Your Ref: OWQC3677
Our Ref: M/41/14/PL
Please ask for:
Mrs A Gardner

4th September 2014

Removal of existing railway carriage dwelling and construction of new 4 bedroom two storey detached dwelling.

102 Ancton Way Elmer Middleton On Sea

DRAWING
PROPOSED ELEVATIONS
DRAWING No
97/07
SCALE 1:100
DATE MAY 2014
REVISION
A
DRAWN LA
CHECKED

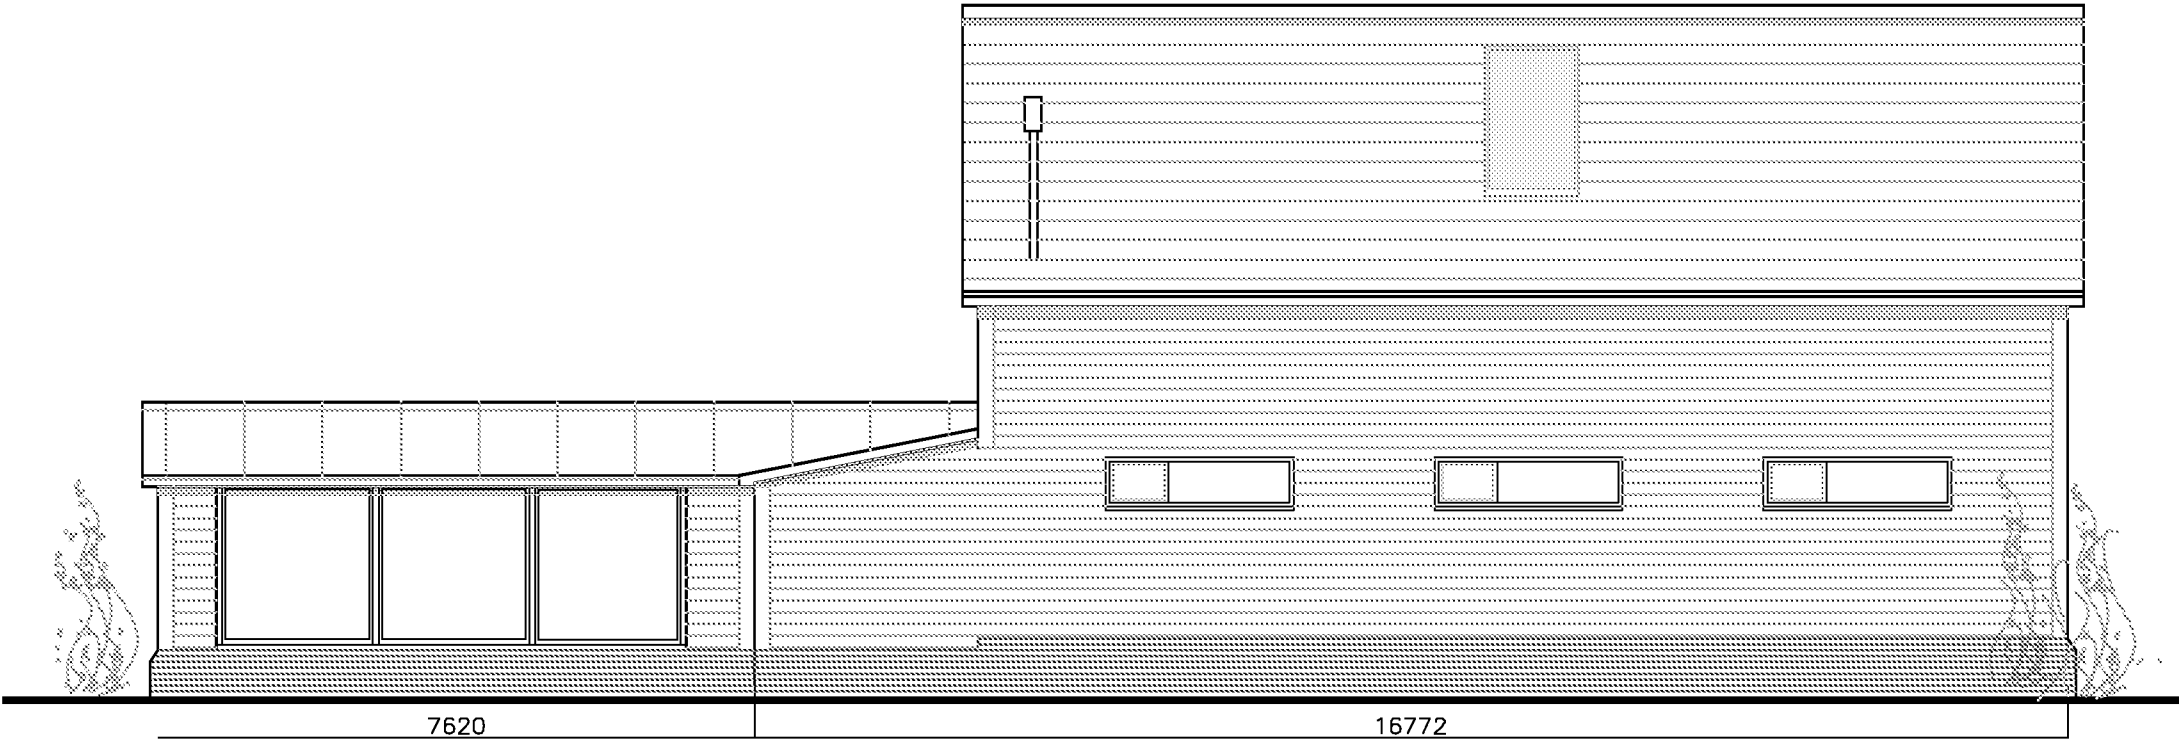
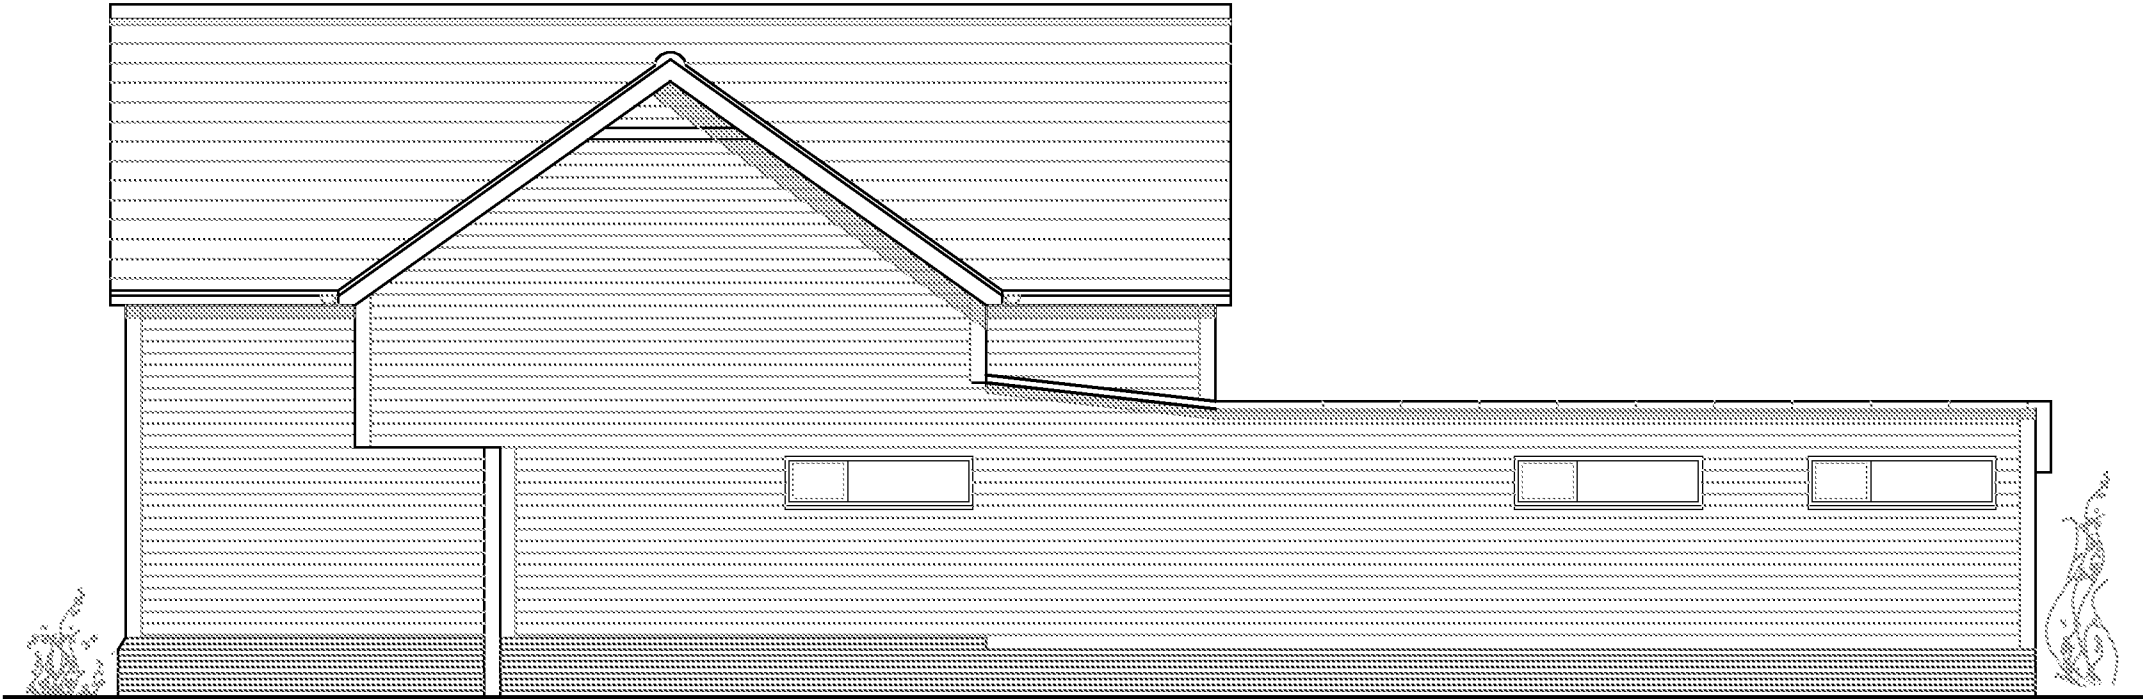
- 1. The overall mass, height & scale is out of keeping with the site.*
- 2. There is a shortage of adequate parking available on the site.*
